WEST SUSSEX COUNTY COUNCIL CONSULTATION

TO:	Arun District Council FAO: David Easton
FROM:	Highways, WSCC
DATE:	28/03/2018
LOCATION:	Land South Of, Burndell Road, Yapton, West Sussex, BN18 0HR
SUBJECT:	F/5/18/RES Approval of reserved matters following outline consent F/7/15/OUT relating to appearance, landscaping, layout & scale for residential development comprising of 45 No. dwellings. This application also lies within the parish of Yapton. Resubmission of F/23/16/RES.
DATE OF SITE VISIT:	N/A
RECOMMENDATION:	☒ Advice ☐ Objection ☐ Modification ☐ No Objection ☐ More Information ☐ Refusal
S106 CONTRIBUTION TOTAL:	N/A

This drawing contains:
Topo = (February-14-2018) 13:4718
Layout = (February-22-2018) 1000 1.01 Rev P5

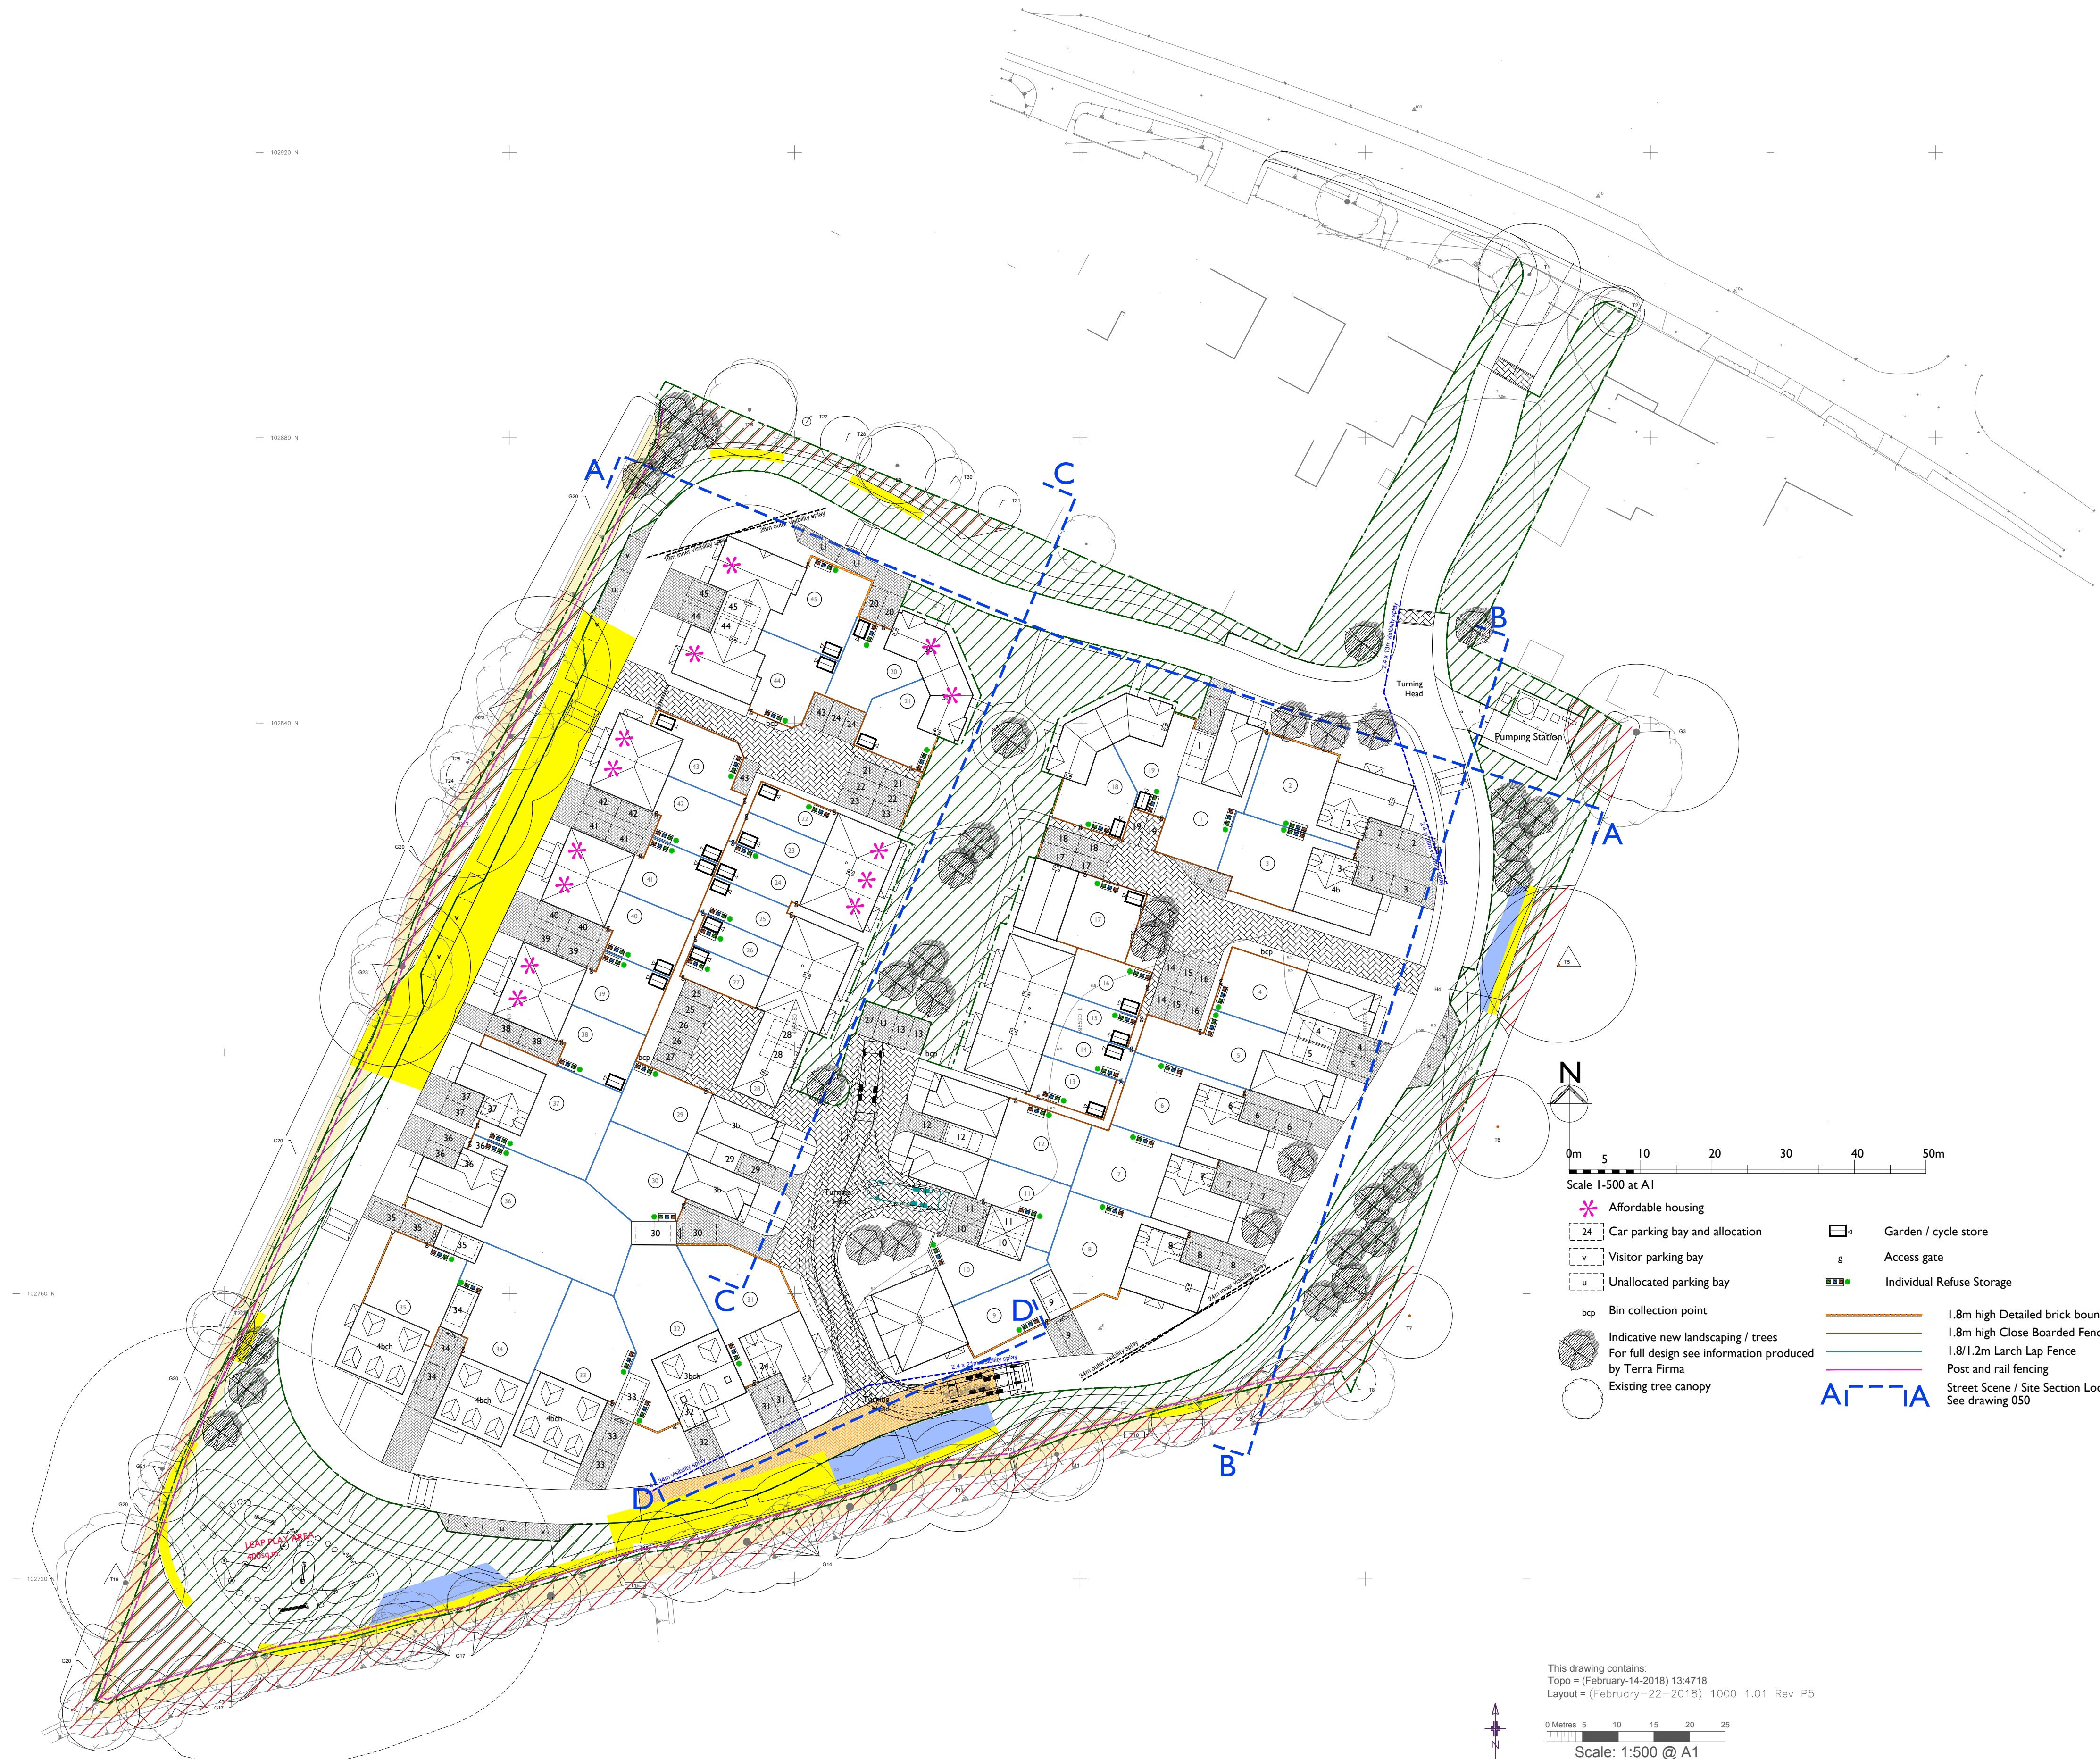
Internal Carriageway-The internal carriageway will be 4.8 metres in width. Visibility splays have been demonstrated satisfactorily and in accordance with Manual for Streets parameters. The LHA are satisfied with the specifications of the internal carriageway.

Footways-Footways will be provided within the site. No specific dimensions have been provided but a 2.0 metre minimum is considered acceptable and in accordance Manual for Streets (MfS) and Inclusive Mobility guidance. A minimum of 1.8 metres should be secured where the applicant has control over the land and if there is the opportunity to widen the footway further, this would be considered a benefit to pedestrians by increasing the effective usable width and enabling greater separation between vehicles and pedestrians in the event that a pedestrian feels intimidated by the presence of vehicles in the adjacent carriageway.

Parking-A total of 101 car parking spaces will be provided on site. This provision has been considered against the WSCC Parking Demand Calculator (PDC). The proposed provision does not exceed the requirement generated by way of the PDC.
